14th April 2019

Re: Planning Statement for FP/30/19/PL No 10 South Road
Re-submission following FP/234/17/PL

Client			Drawing		Scale: A3	
Regent Properties Ltd			Floor Plans		1:100	
			Job number	Drawing number	Revision	
			15.007	02	A

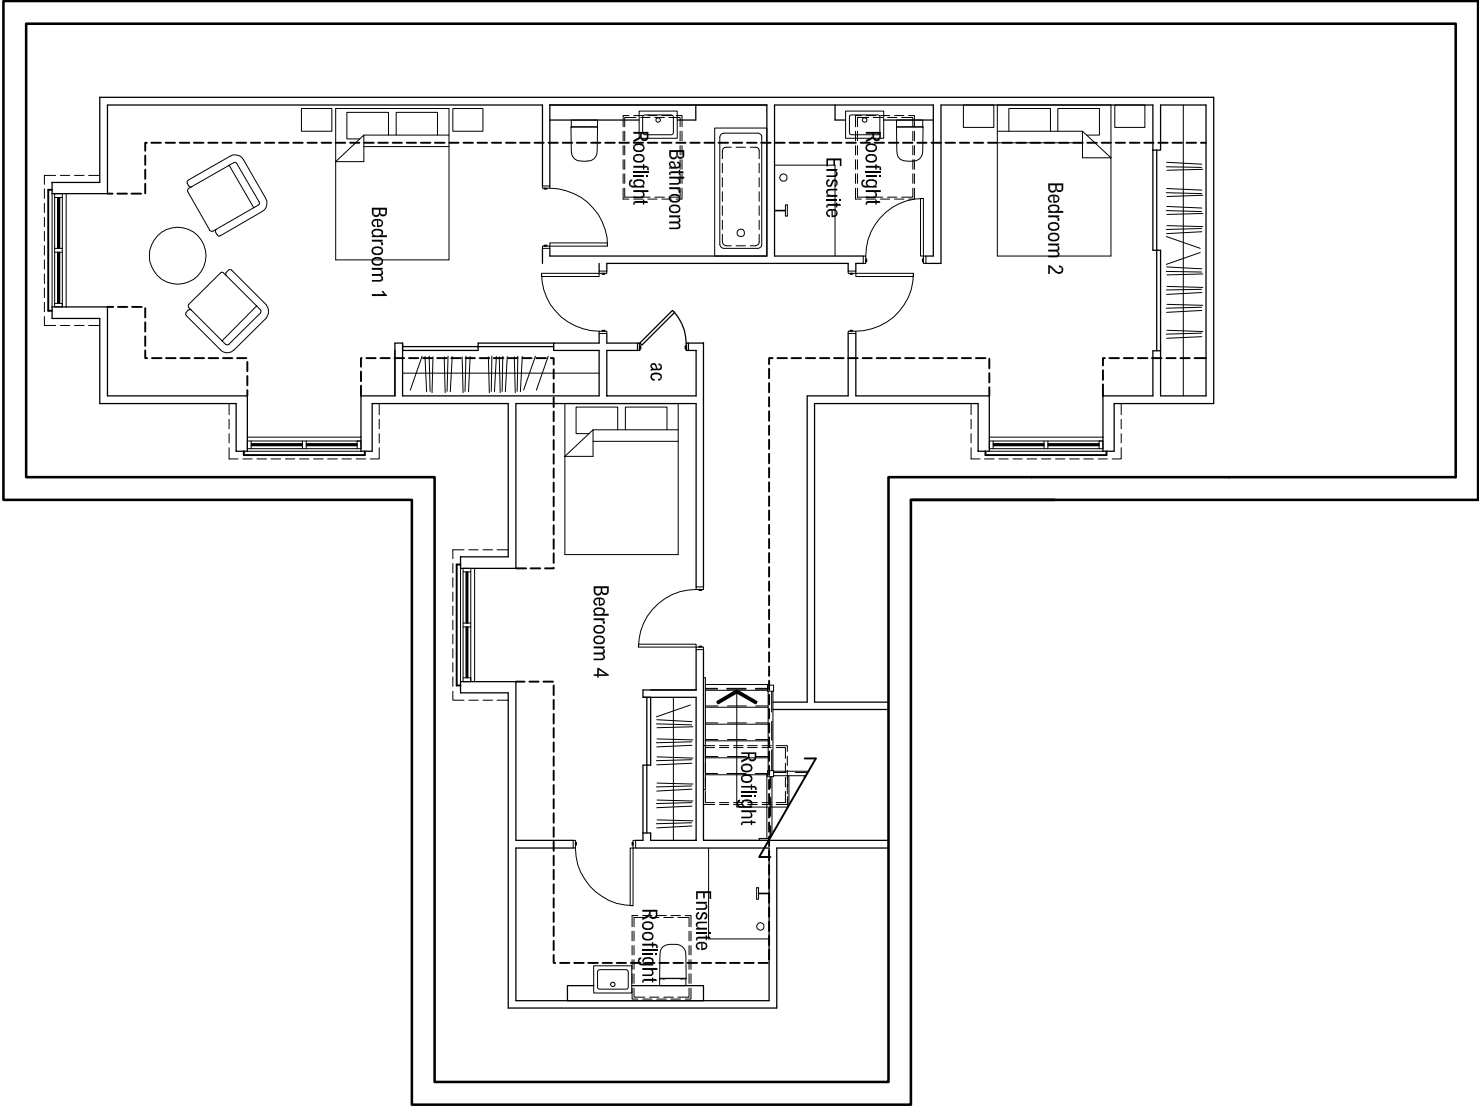
The Chalet footprint is 2½ times this at 181m².

Elevations

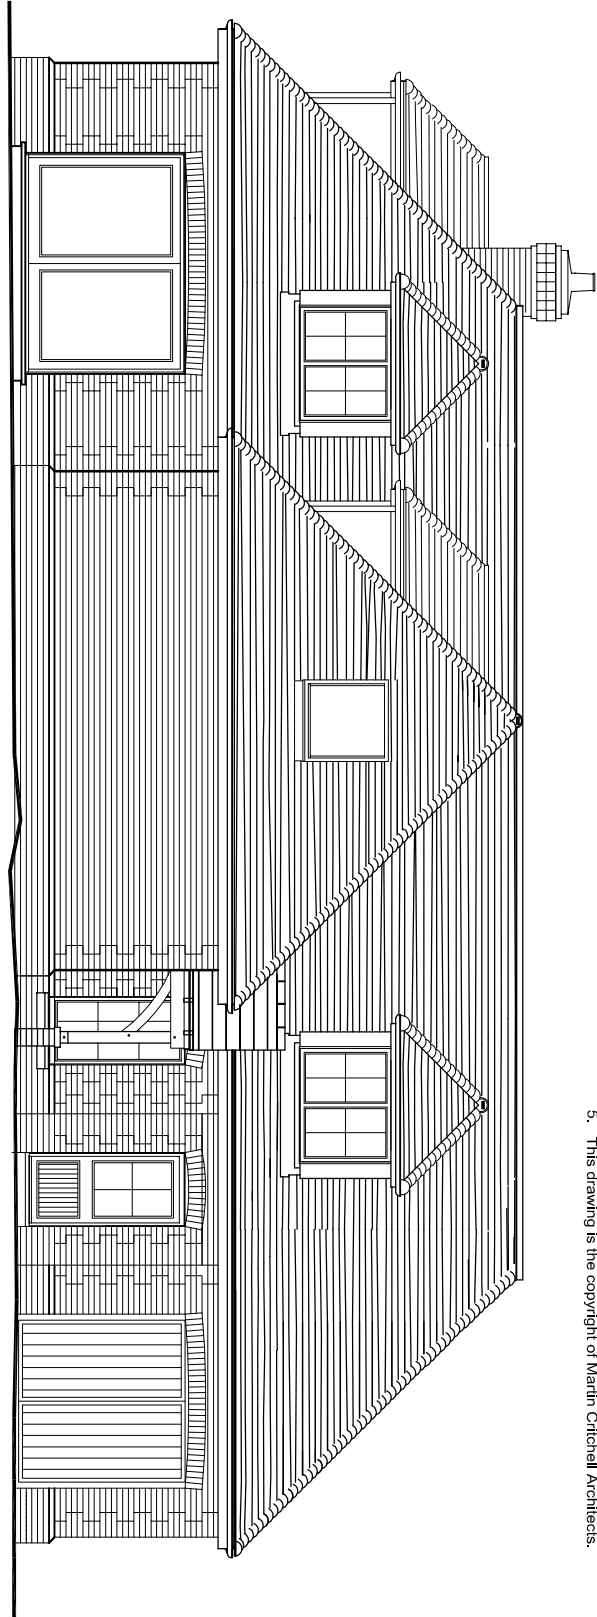
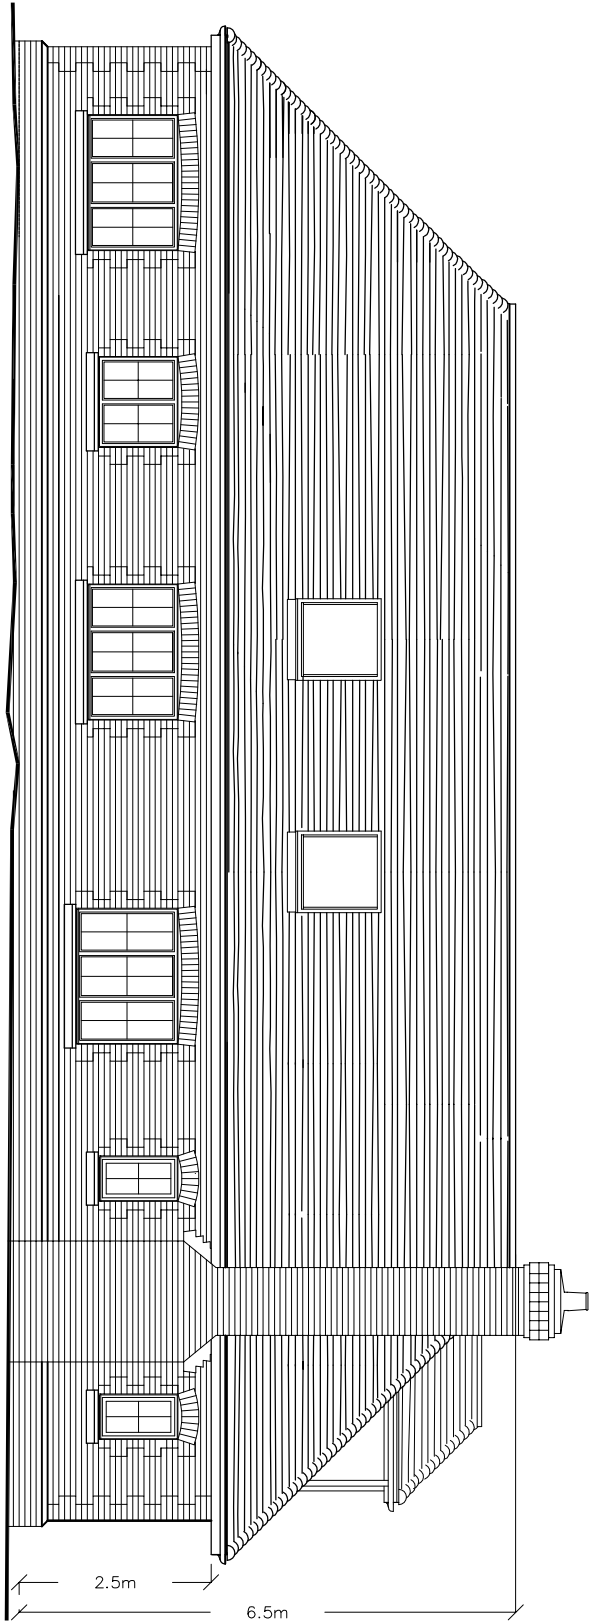
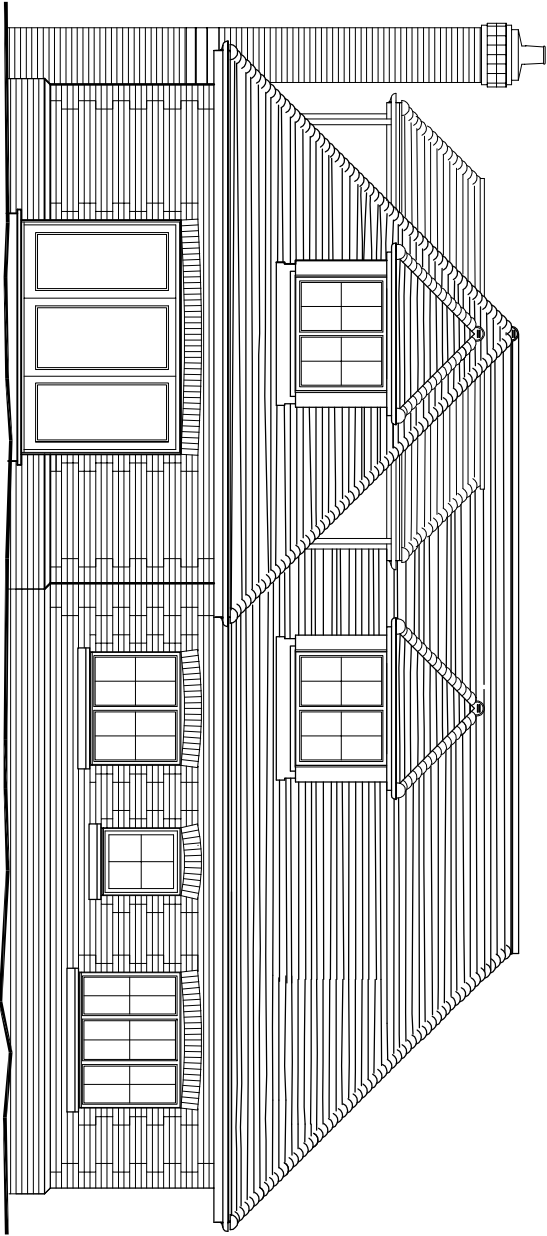
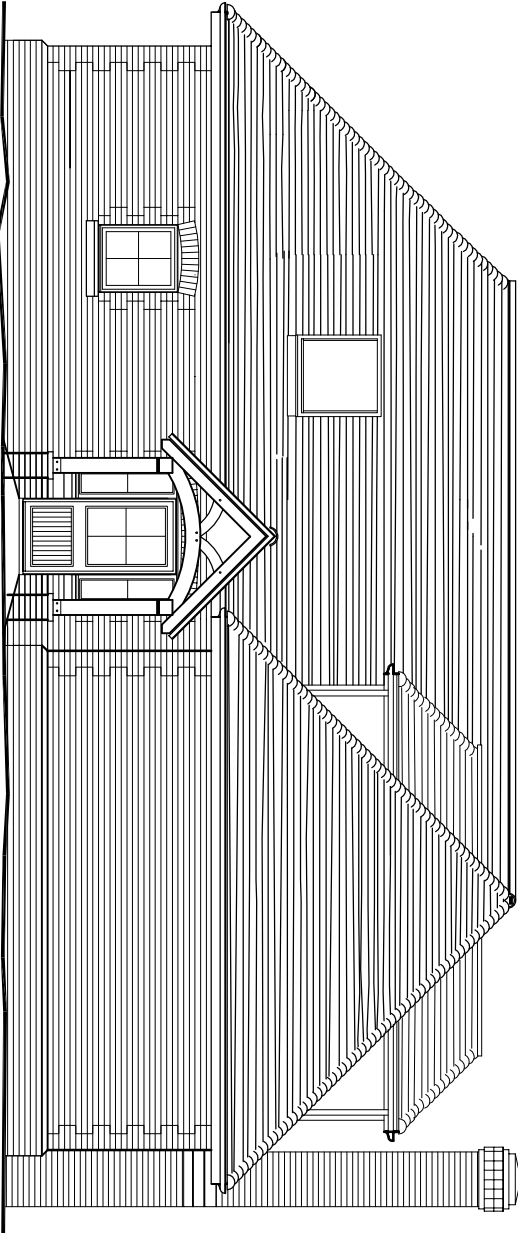
The applicant is also incorrect when stating that his chalet's broadest elevation would look southwards, since this elevation would be only 14.6m wide, while the east and west elevations would be 19.5m. Furthermore, the east facing dormer for bedroom 1 would face directly over No 9's garden, as acknowledged by him later, within the considerable muddle written under 6. Fenestration.
